## **Response to Parramatta Light Rail EIS**

23 October 2017

This submission is made on behalf of Western Sydney University by the Office of Estate Master Planning and Strategy and the Office of the Deputy Vice-Chancellor Research, Engagement, Development and International.

Figure 5.16 Indicative plan – Parramatta Square stop

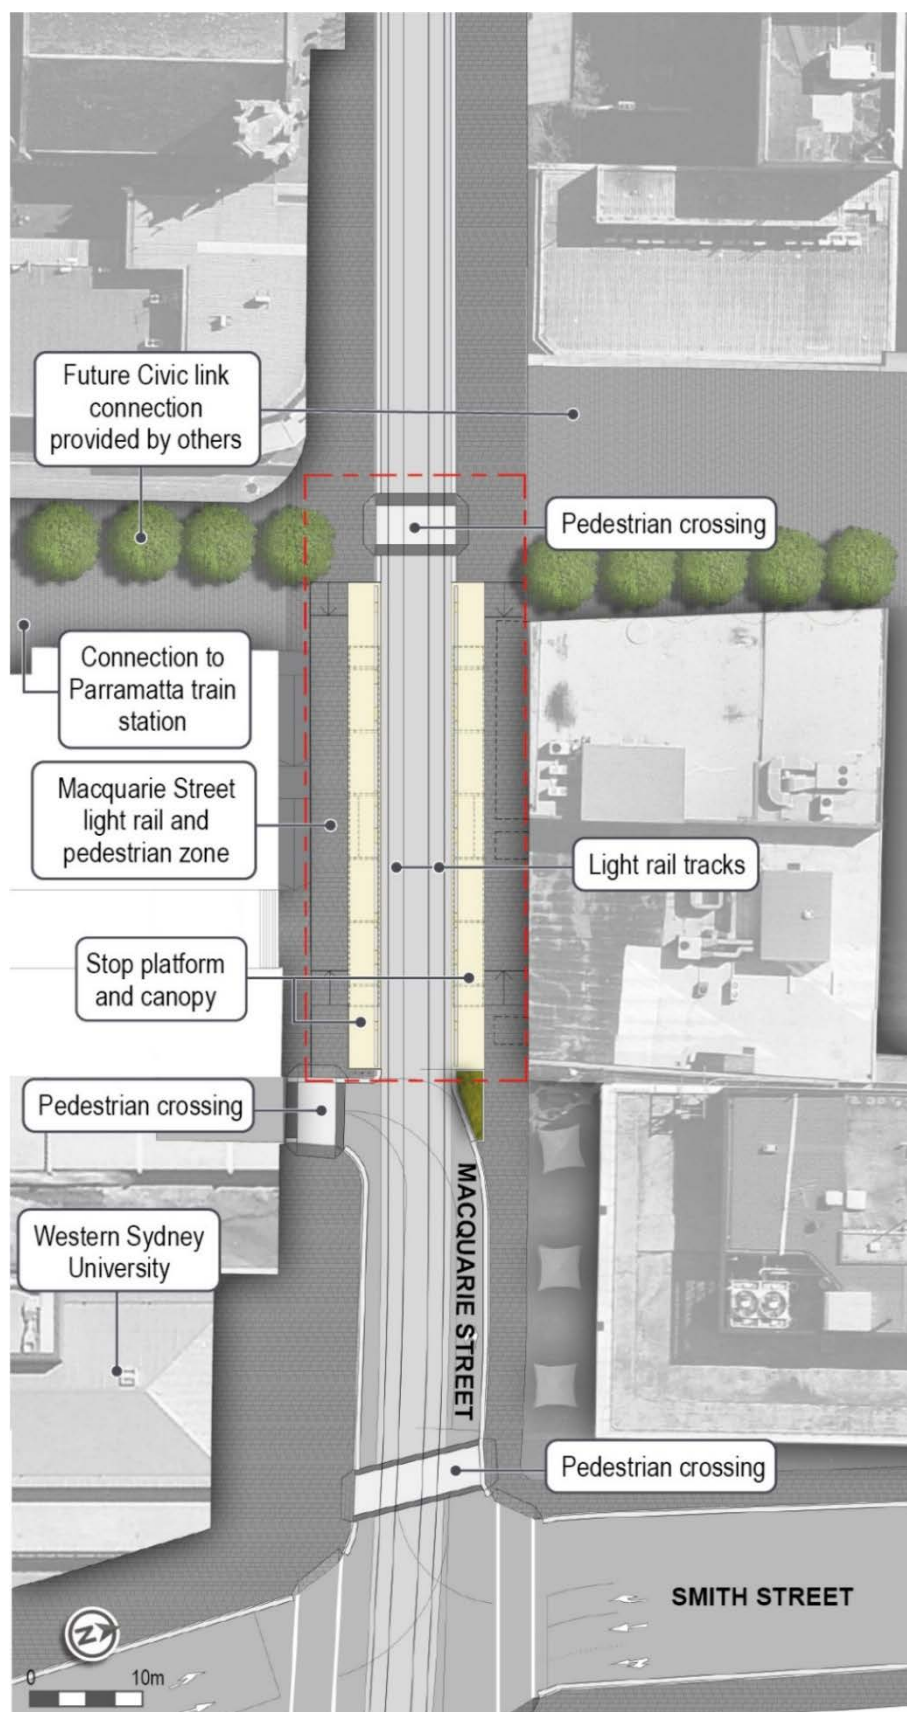
The University notes the planned traffic changes to Macquarie St and, in particular, the plans for car park access to Parramatta Square outlined at 5-43 of the EIS. While the existing carpark access to 1PSQ is located where figure 5.16 suggests, a more permanent solution to access to public underground car parking at Parramatta Square is contained in the Parramatta Square Access Strategy (Aurecon 2015). In this strategy, the underground carpark in Parramatta Square is accessed via Civic Place and then, Macquarie Lane.
